Application for a non-material amendment following a grant of planning permission.

ERECTOR OF A TWO STOREY REAR EXTENSION AND
GABLET DORMER WINDOW TO MATCH EXISTING TO FORM
EXTENSIBLE RESIDENTIAL ACCOMMODATION

3/2016/0412

INCREASE THE GROUND FLOOR FOOTPRINT TO THE WEST AND
WITHIN THE INTERNAL GARDEN AREA TO ALLOW A UTILITY AREA

Drawing no 6006 a/a

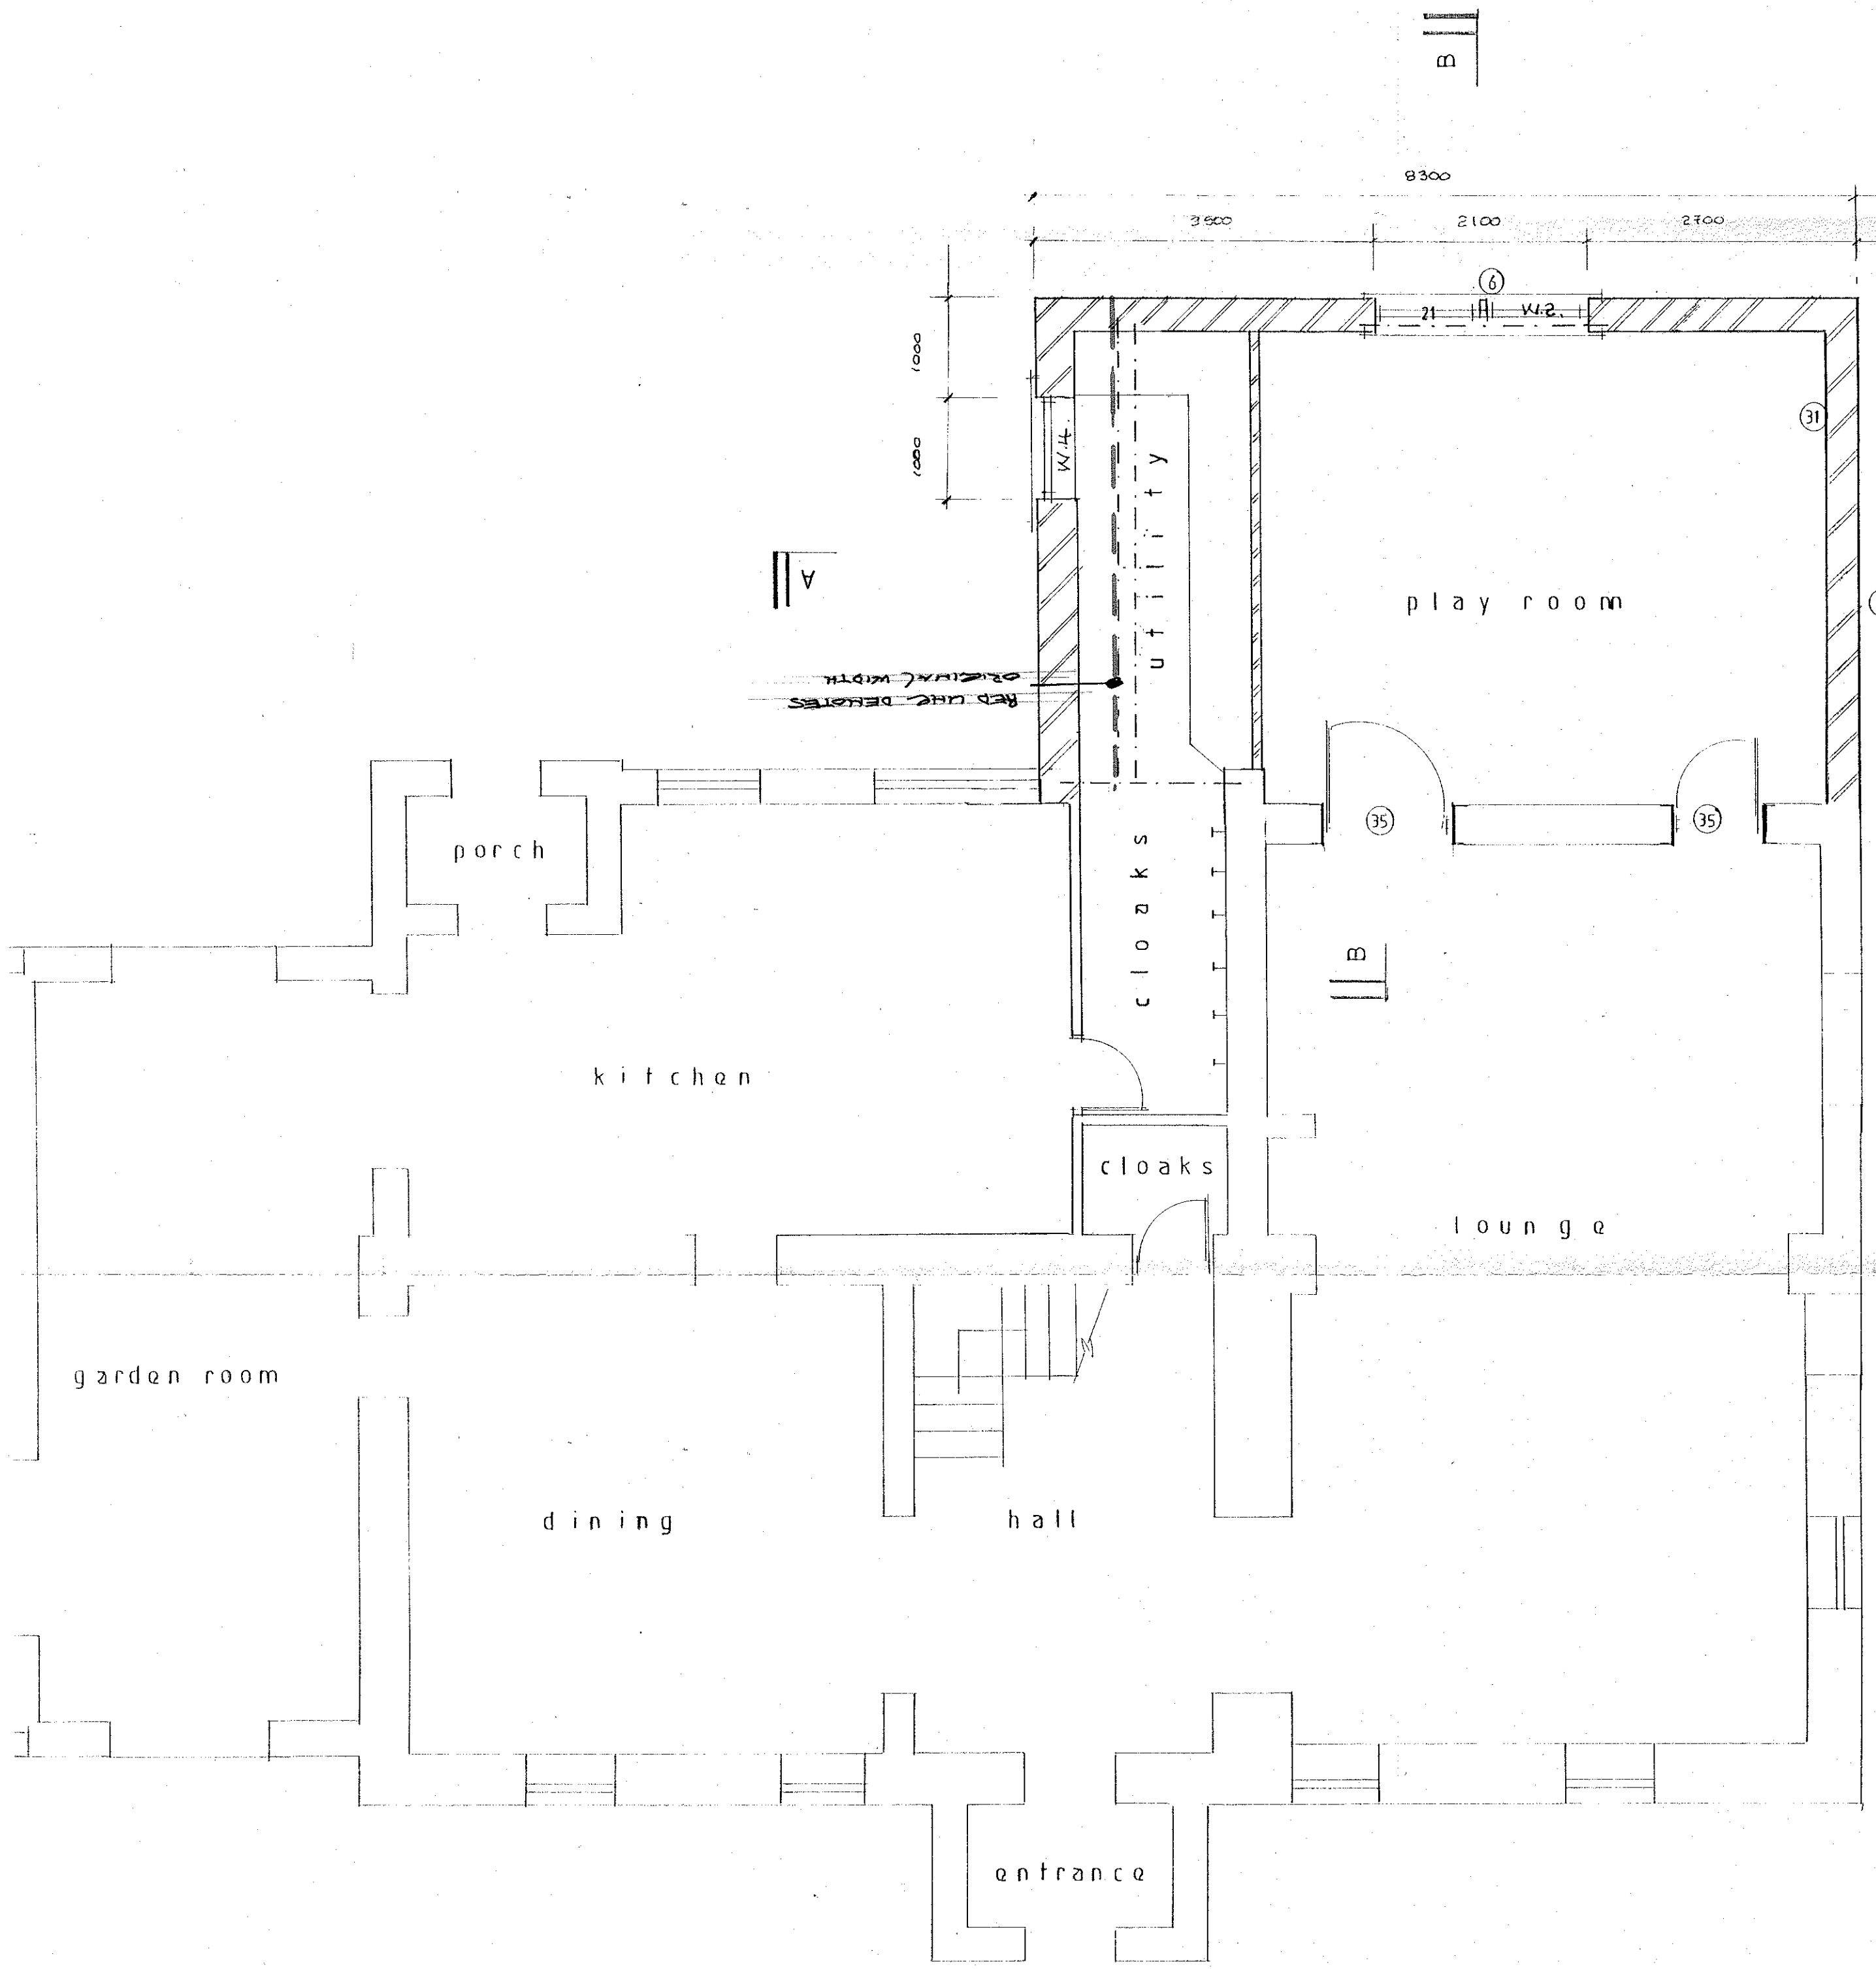
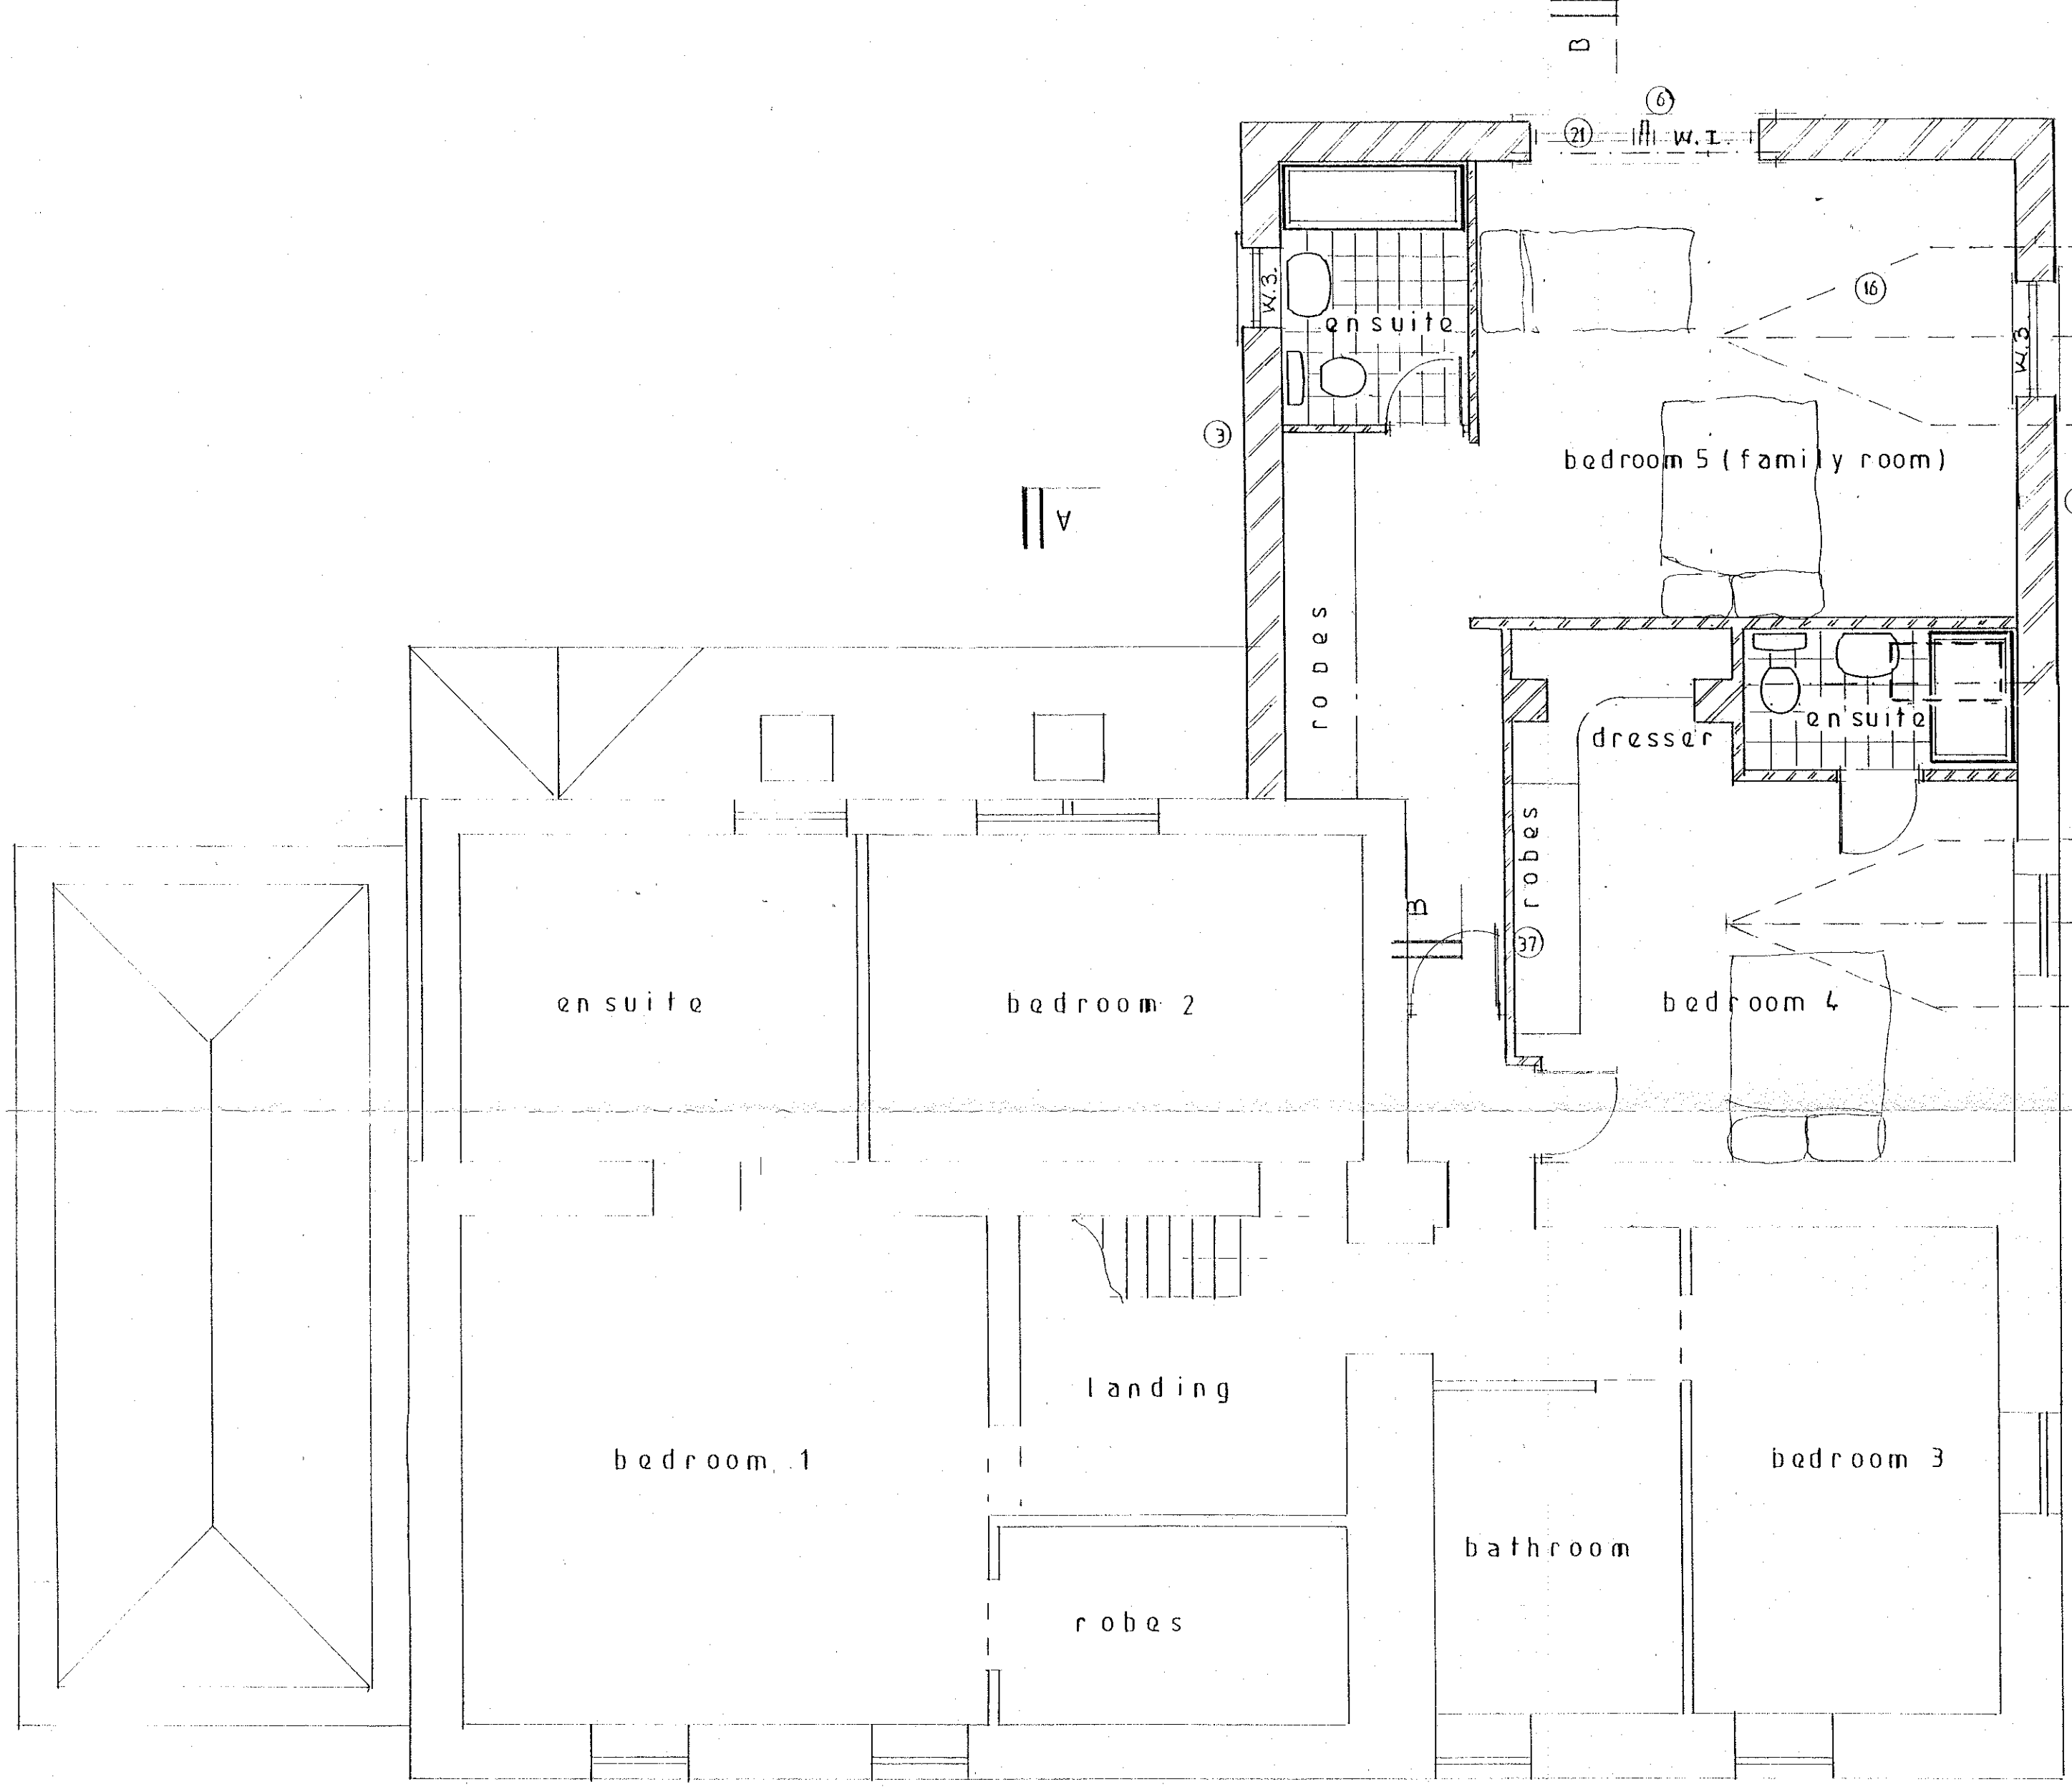
6006a & 6007a

6006/b & 6007/b. AND 6008
